WEST SUSSEX COUNTY COUNCIL CONSULTATION

TO:	Arun District Council FAO: Katie Sharp
FROM:	WSCC - Highways Authority
DATE:	30 May 2022
LOCATION:	The Grange, Westergate Street, Westergate, PO20 3SQ
SUBJECT:	AL/55/22/DOC Approval of details reserved by condition imposed under AL/28/21/PL relating to conditions 3-schedule of materials and finishes, 5-Construction Management Plan, 6-protection of dwellings from noise and vibration from railway line, 8-covered and secure cycle parking, 9-level survey, 10-surface water drainage, 11-foul drainage system, 13-landscaping, 15-Landscape and Ecological Management Plan and 16-electric vehicle charging points.
DATE OF SITE VISIT:	N/A
RECOMMENDATION:	Advice
S106 CONTRIBUTION TOTAL:	N/A

This proposal seeks the approval of details reserved by Conditions 3, 5, 6, 8, 9, 10, 11, 13, 15 and 16 of approved application AL/28/21/PL. WSCC in its role as Local Highway Authority (LHA) provided consultation advice for application AL/28/21/PL, raising no highway safety concerns.

FIGURE 3

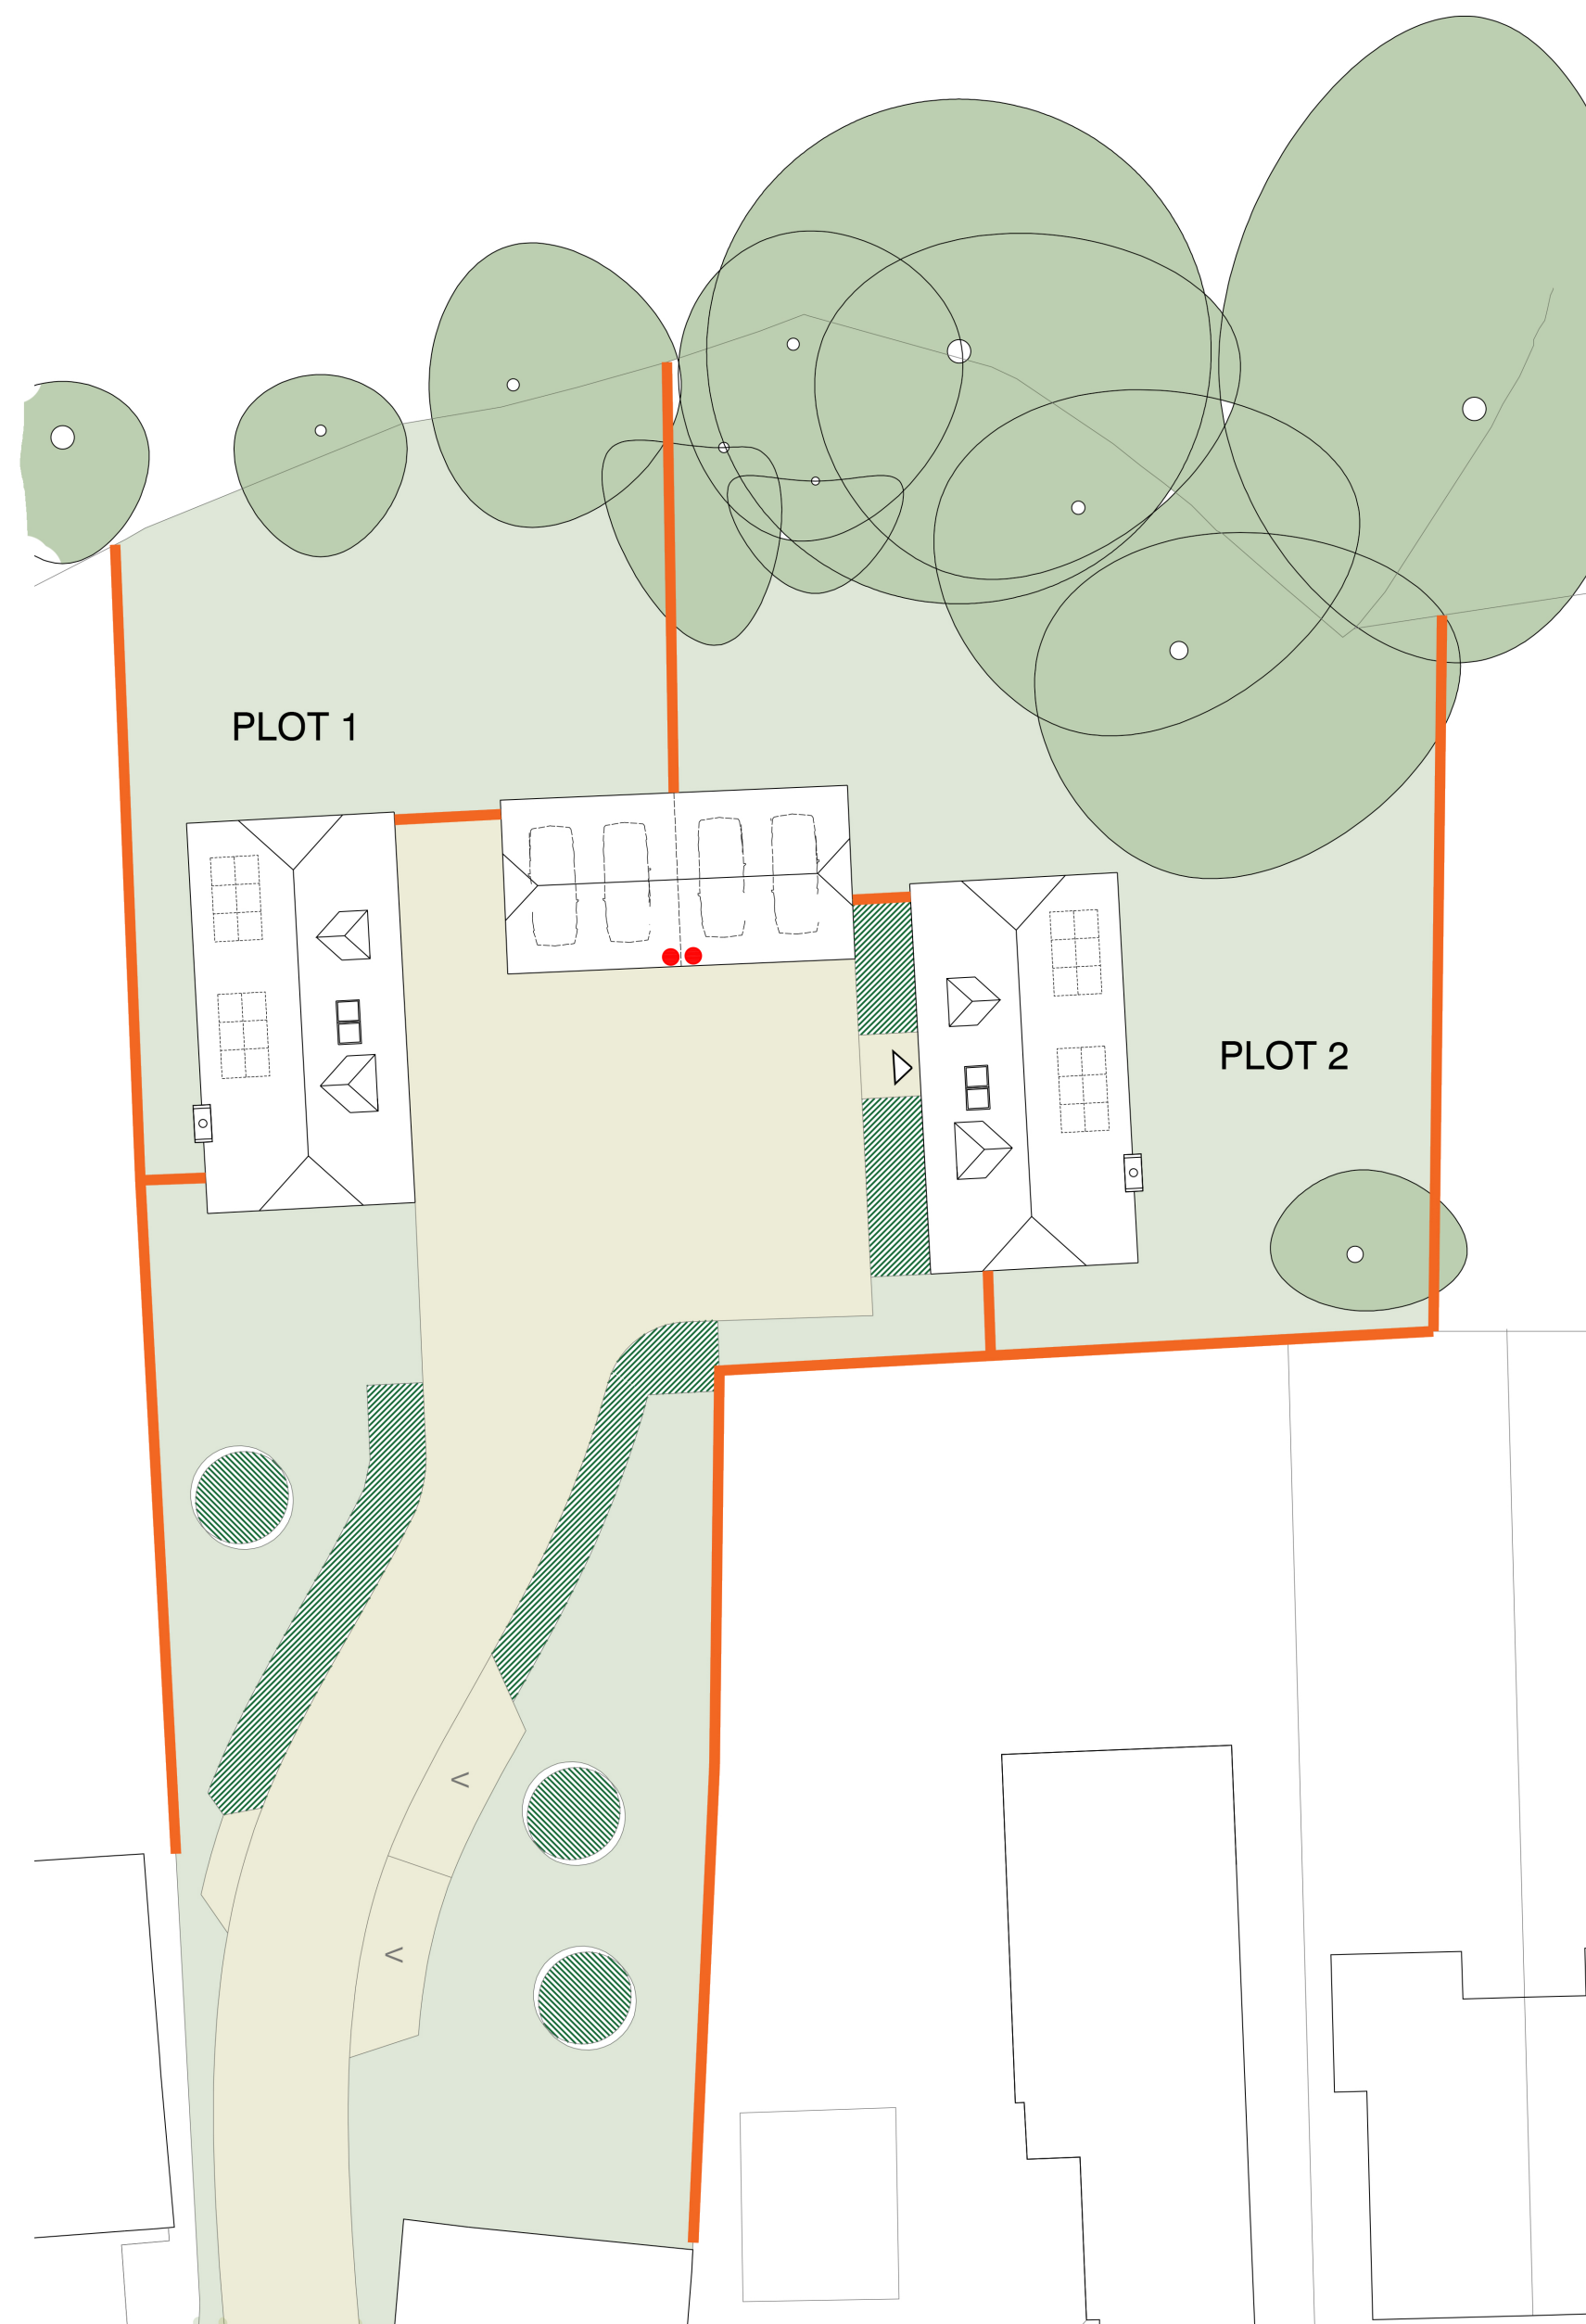
The applicant has submitted a Site Plan (1251/FIGURE 3), demonstrating the location of two Pulsar Plus EV charging points within two of the proposed garages.

In summary, the LHA is satisfied that Condition 16 can be discharged.
